**PROPOSED CONNAH'S QUAY LOW CARBON POWER**

**PROJECT PLANNING INSPECTORATE REFERENCE: EN010166**

**RE: NATURAL RESOURCES WALES' WRITTEN SUBMISSION FOR DEADLINE 3**

Plate 1 Photograph showing the saltmarsh creek (the Existing Surface Water Outfall is 5 m behind), the top of the corridor berm, high water terrace and drainage flattened grasses above the narrow creek

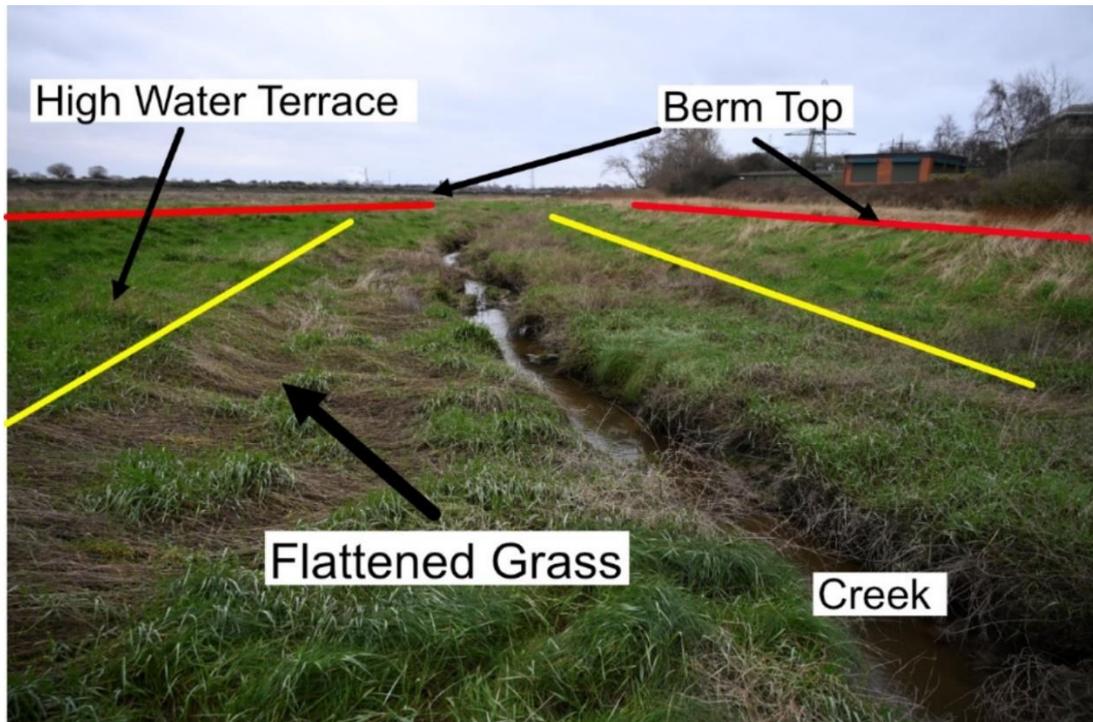
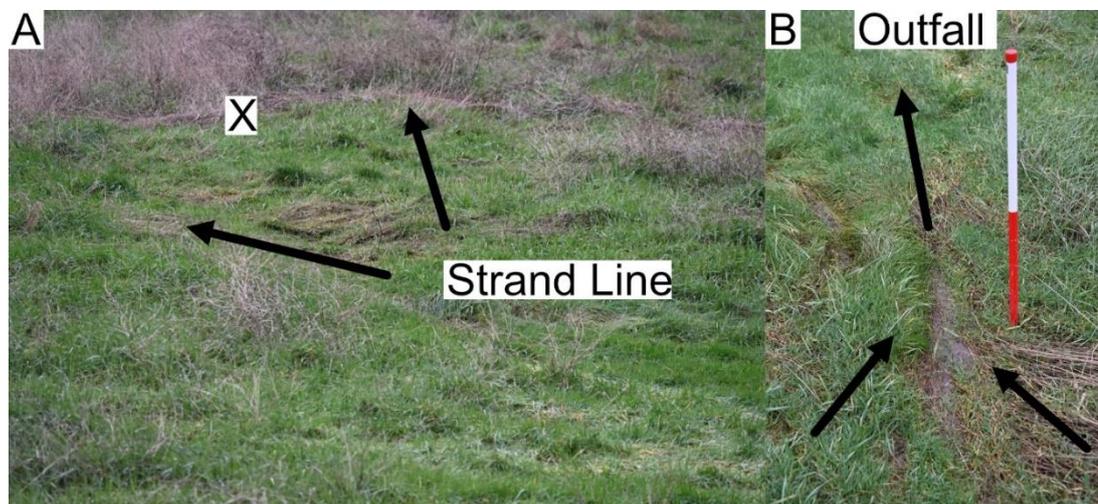
- B.1.3 However, adjacent to the outfall structure there is evidence of scour from a combination of outfall discharge and tidal ingress resulting in a vortex and an area of erosion; this is supported by plate 3 and paragraph 3.1.3 of the report.

- B.1.6 Plate 3 shows that saltmarsh is extending across the discharge channel which could affect how water discharges from the surface outfall. The Applicant should therefore confirm whether they intend on clearing the channel at this point and, if so, whether this has been accounted for within the RIHRA.

- B.1.5 We therefore advise that the Applicant should undertake an assessment of scour for the new permanent surface water outfall. The design of the outfall should consider best practice to reduce scour such as the headwall not projecting beyond or above the bank. If scour protection is required, this should include the use of natural materials.
